Principal Areas of Disagreement Summary Statement (PADSS) from Surrey County Council - Version Number: ~~Two-Three~~ Submitted at: Deadline ~~Two-Nine~~
- 26th-21st ~~March-August 2023~~2024

**Figure 14: Location of Contractor Compounds**

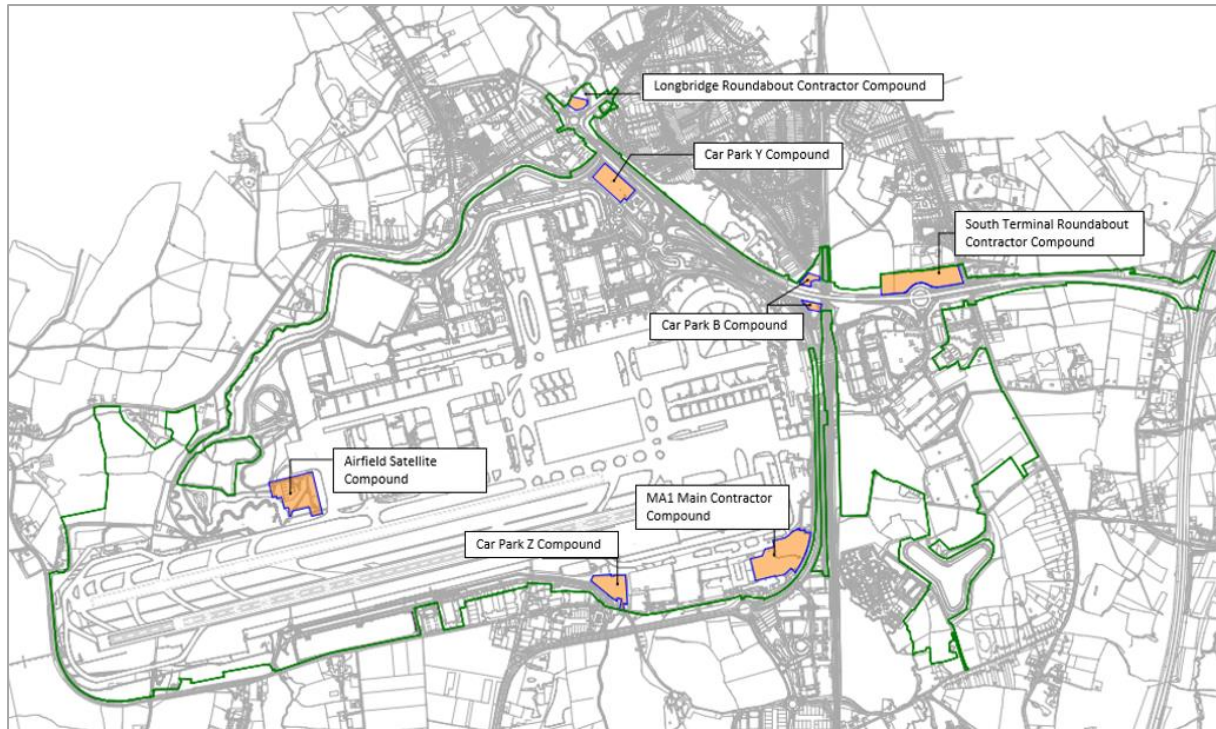
2122	Securing mitigation	<p>The entrance to the Longbridge Roundabout compound is not defined.</p>	<p>SCC seeks confirmation of requests that further information is provided for the Longbridge construction compound. The existing access</p>	Likely <u>Addressed</u>

Ref	Principal Issue in Question	Concern held	What needs to change/be amended/be included in order to satisfactorily address the concern	Likelihood of concern being addressed during Examination
			is considered inappropriate as detailed in the LIR. SCC is content that detailed design will be finalised with the agreement of the highway authorities.	
2223	Securing mitigation	SCC is concerned that separate entrances to the South Terminal compound are proposed for HGVs (from the roundabout) and private vehicles (from Balcombe Road). This implies that an extended journey on the local road network is required.	SCC wishes to see all access to the South Terminal compound from the South Terminal Roundabout. <u>SCC remains concerned that the proposed Balcombe Road access is referenced in DCO documentation.</u>	Uncertain <u>Not addressed</u>
Drainage and impact on Lead Local Flood Authority				
23	Clarity required around climate change allowances used in relation to the water environment	Only contains details of fluvial climate change allowance. Surrey County Council design guidance recommends using the Upper End rather than Central when determining climate change allowances.	Pluvial climate change allowances should be included, or if none being applied. Rationale required. Further detail has been provided in GAL's SoCG response. No further comment.	Likely <u>Addressed</u>
